Date: August 26, 2024

FROM: Margaret Haynes, NMDOT Assistant District 3 Traffic Engineer

SUBJECT: Mountain Rd Rehabilitation Hospital Crash Analysis and  
Mountain Rd. Rehabilitation Facility Traffic Study  
I-25 Southbound off-ramp and Mountain Rd.  
Albuquerque, New Mexico

The NMDOT received the DRAFT Crash Analysis and Draft Traffic Study. District Three's comments are below.

<b>NOBIS REHAB HOSPITAL</b> 1100 WOODWARD PL.	DRAWN BY pm
	<b>SITE PLAN</b>	DATE 10-3-24
	5571 MIDWAY PARK PL NE ALBUQUERQUE, NEW MEXICO 87109 (505) 858-3100 www.tierrawestllc.com	DRAWING 2023123-SP
RONALD R. BOHANNAN P.E. #7868	SHEET # <b>SP-1</b>	JOB # 2023123

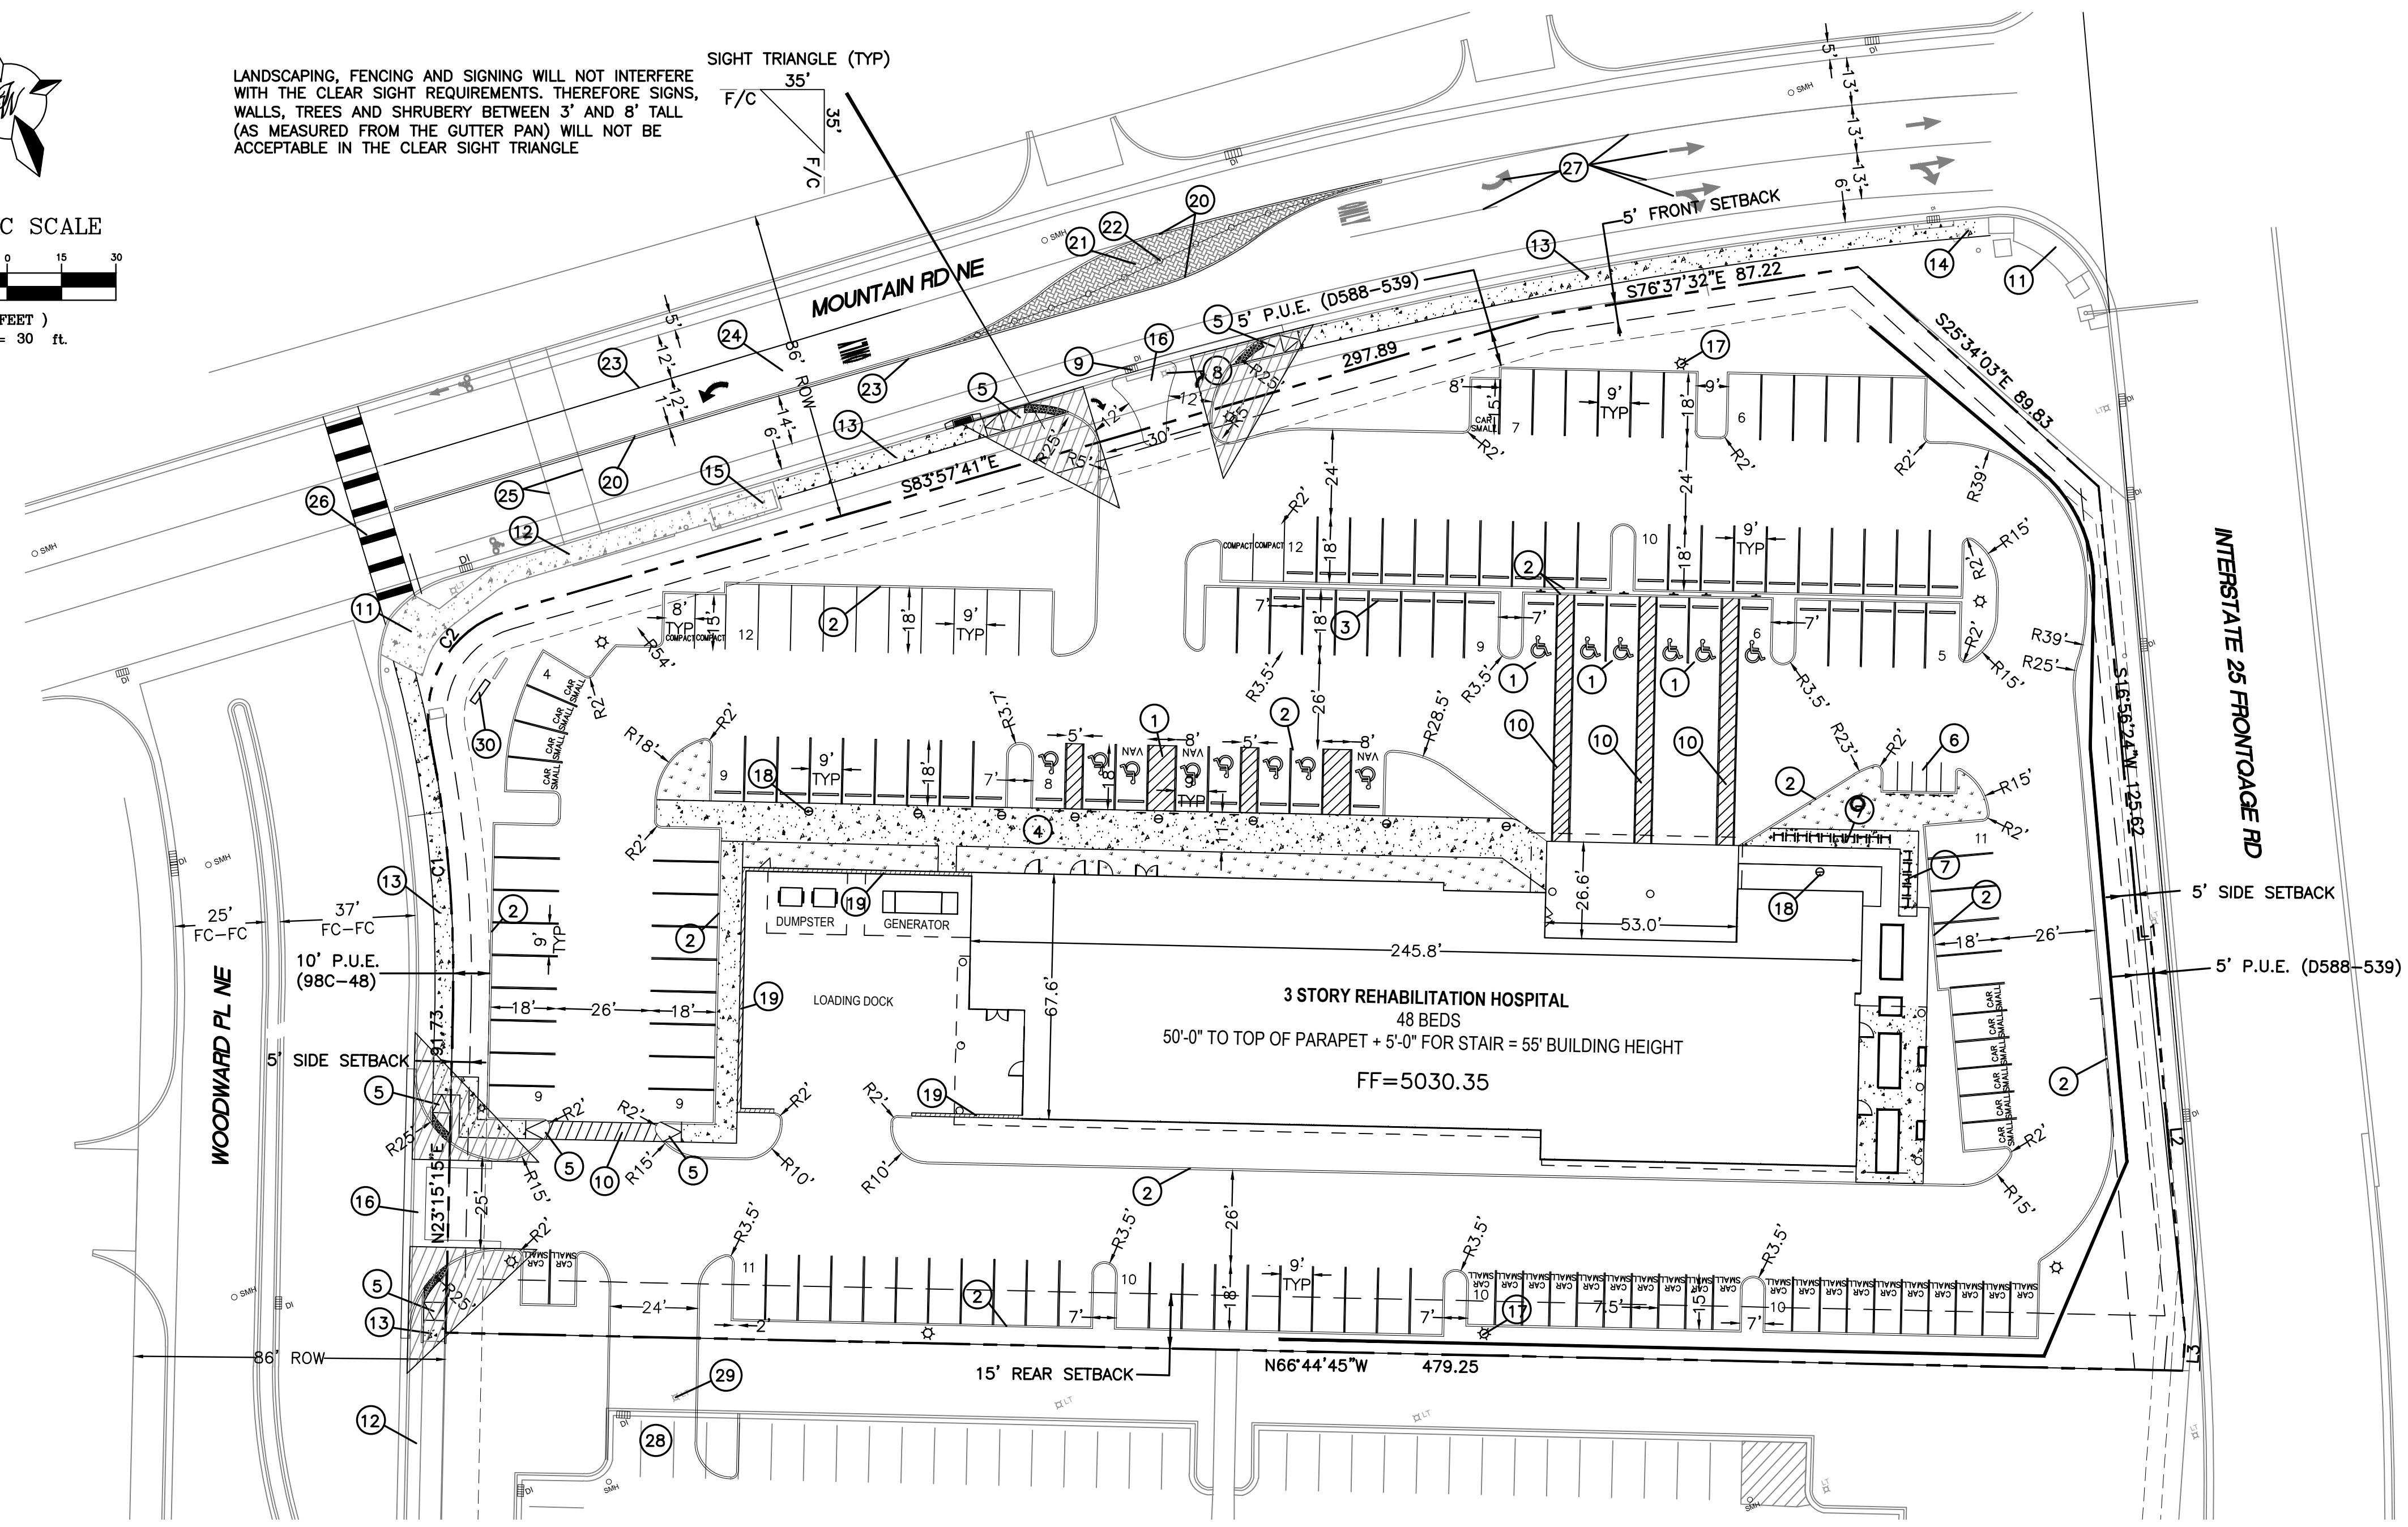
Page 3 – The original request was one access on Mountain OR full access via Embassy Suites easement. The request is now three access points. NMDOT recommends access to be limited to one access point. Please provide additional support for request of three access points.

Page 32- Please provide site plan with access spacing labeled from proposed access to I-25 Southbound FR and Woodward.

- If access on Mountain is allowed, it shall be a limited access right in/out only via an driveway median.
- Install signal head visors on E. Frontage Road to limit visibility from W. Frontage Road for eastbound and add signal head visors on W. Frontage Road to limit visibility of W. Frontage Road westbound.
- Install lane designation sign on mastarm on southbound approach.
